DELEGATED REPORT

APPLICATION NUMBER	S6/2005/0225/FP and S6/2005/0226/LB
LOCATION	Mymwood House, Shepherds Way, Brookmans Park, Hatfield
PROPOSAL	Alterations and Extensions to Care Home

Drawing No JDA/03/940/P.APP/ELEVS.001

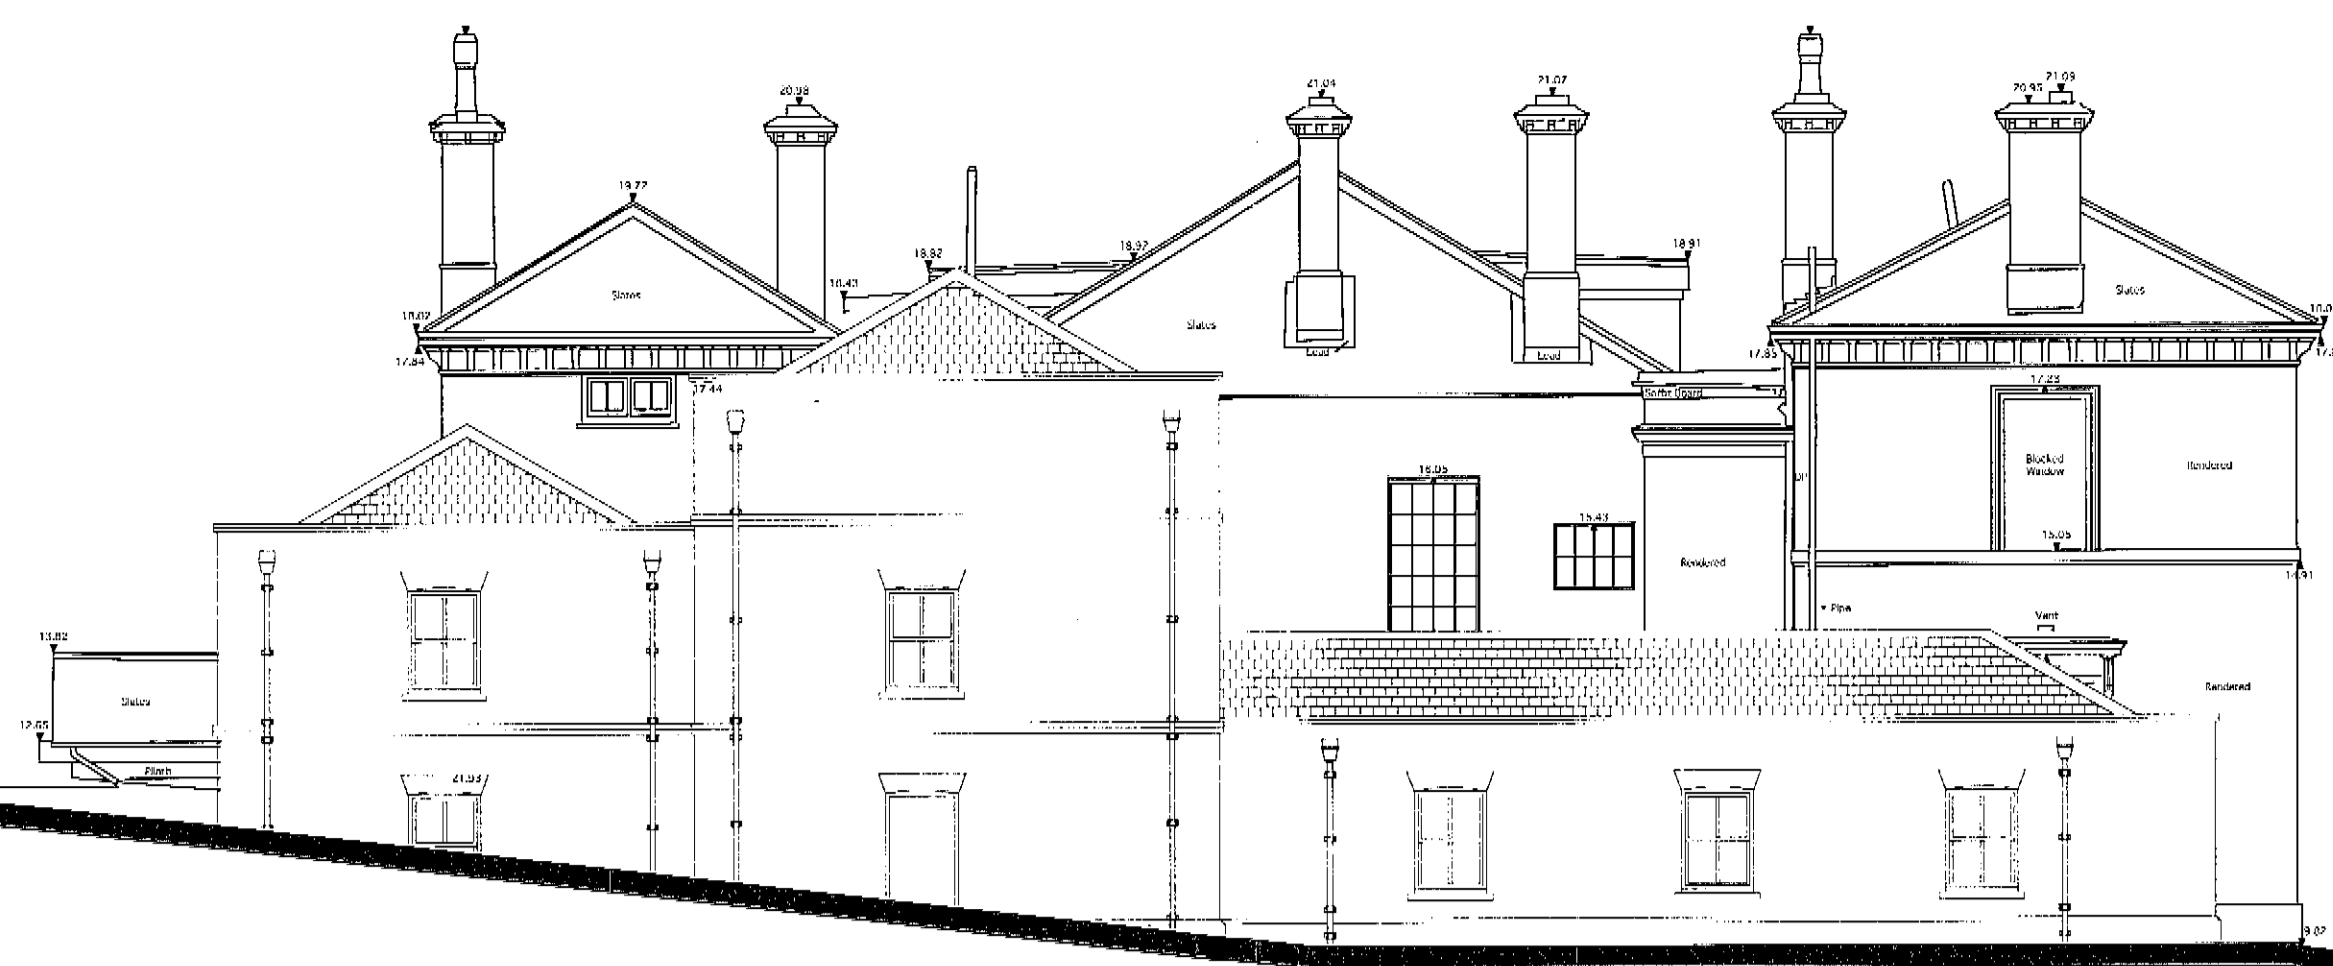
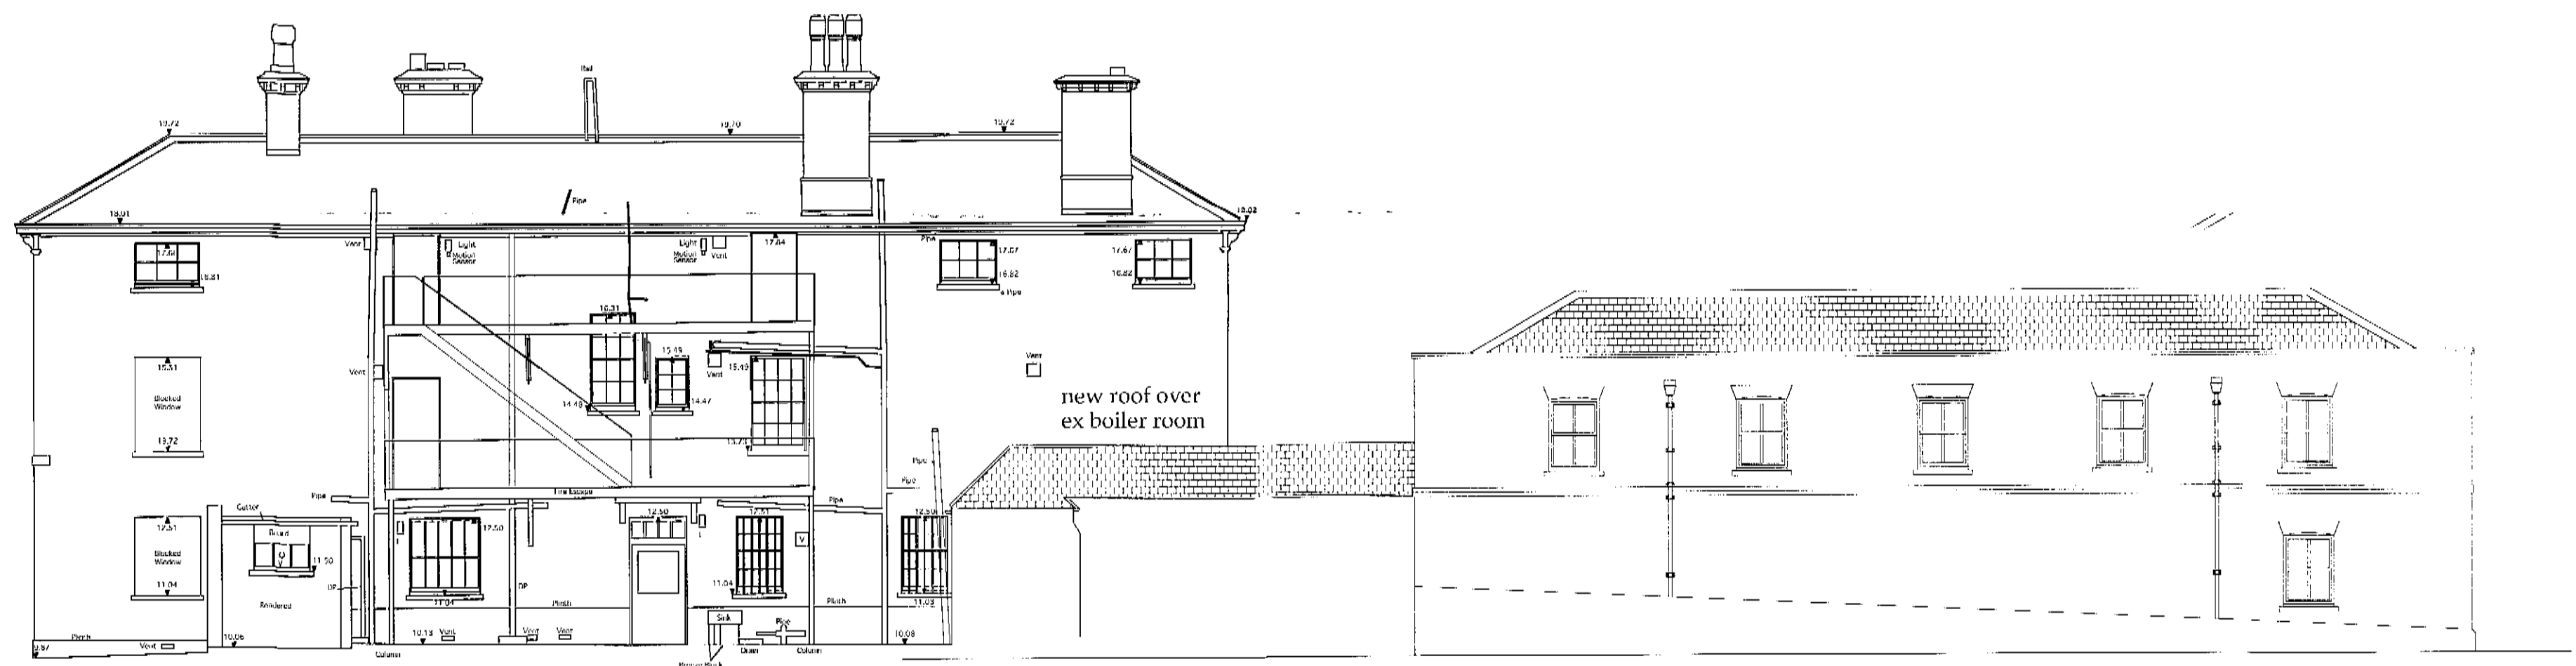
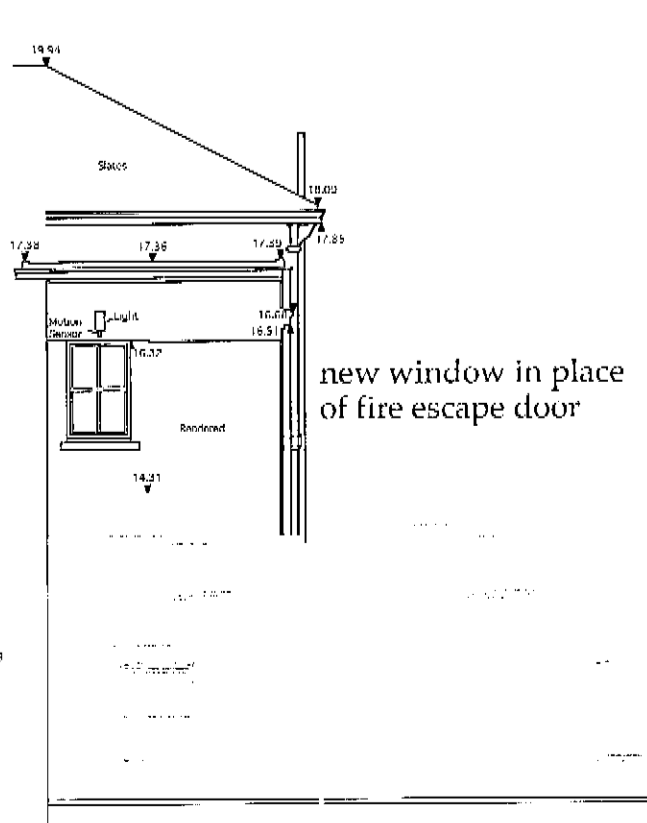
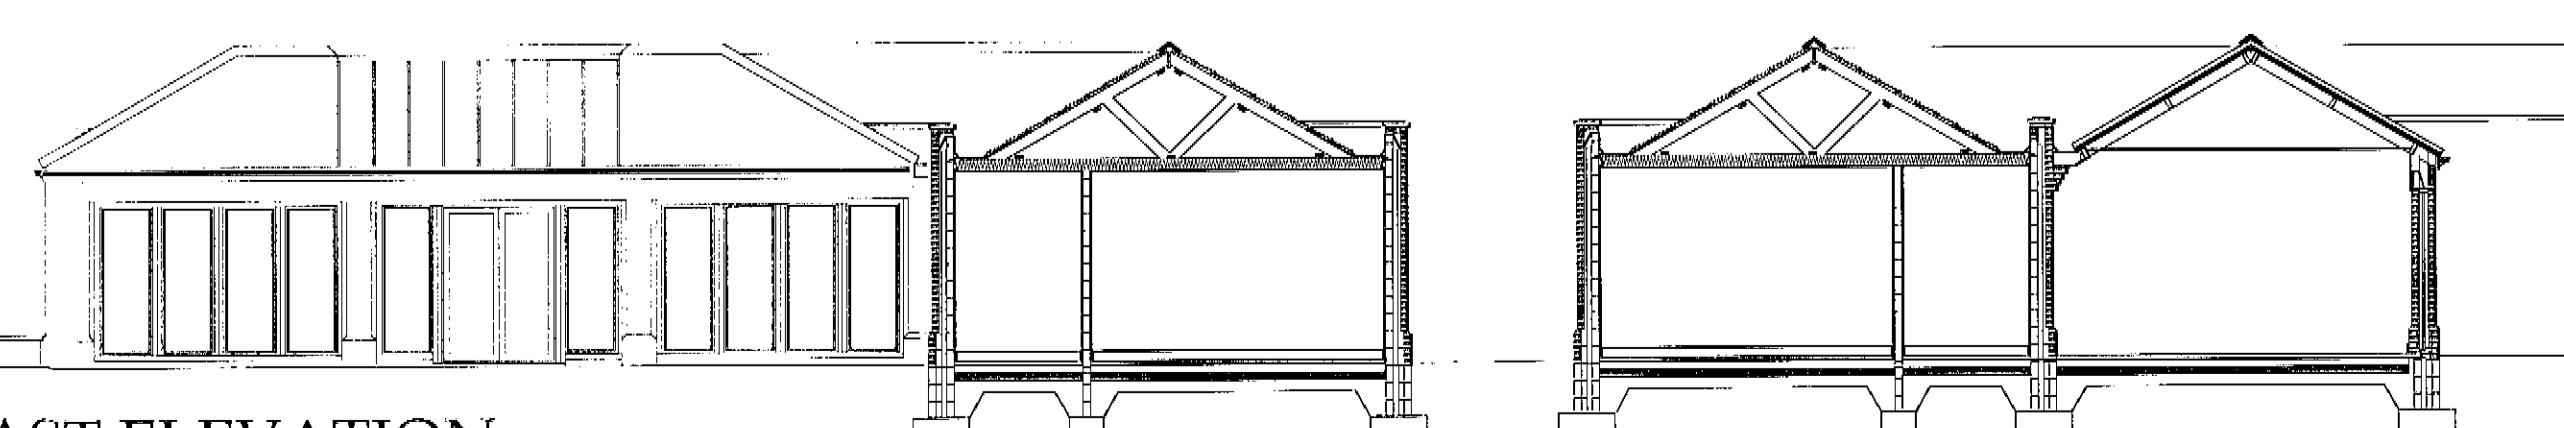
Mr Craig considers that the applicant has responded partly to the suggestions made at the meeting in December 2004, but he is not satisfied with the combination, in the location and form proposed, of one and two storey accommodation. Mr Craig considers that the large tall block on the north elevation is particularly bulky and unattractive. It seems be wasteful of space on the upper level which is occupied by a lift, plant room, staircase and questionable circulation space. This block protrudes awkwardly into the proposed courtyard, as does the proposed conservatory. Perhaps with appropriate hard and soft landscaping the courtyard space can be treated in a manner that will render it more practical and visually acceptable.

The proposals do not respect the character, appearance and setting of the building in terms of design and scale and will detract from the appearance of the existing building to the detriment of the character and appearance of the Listed Building as a whole.
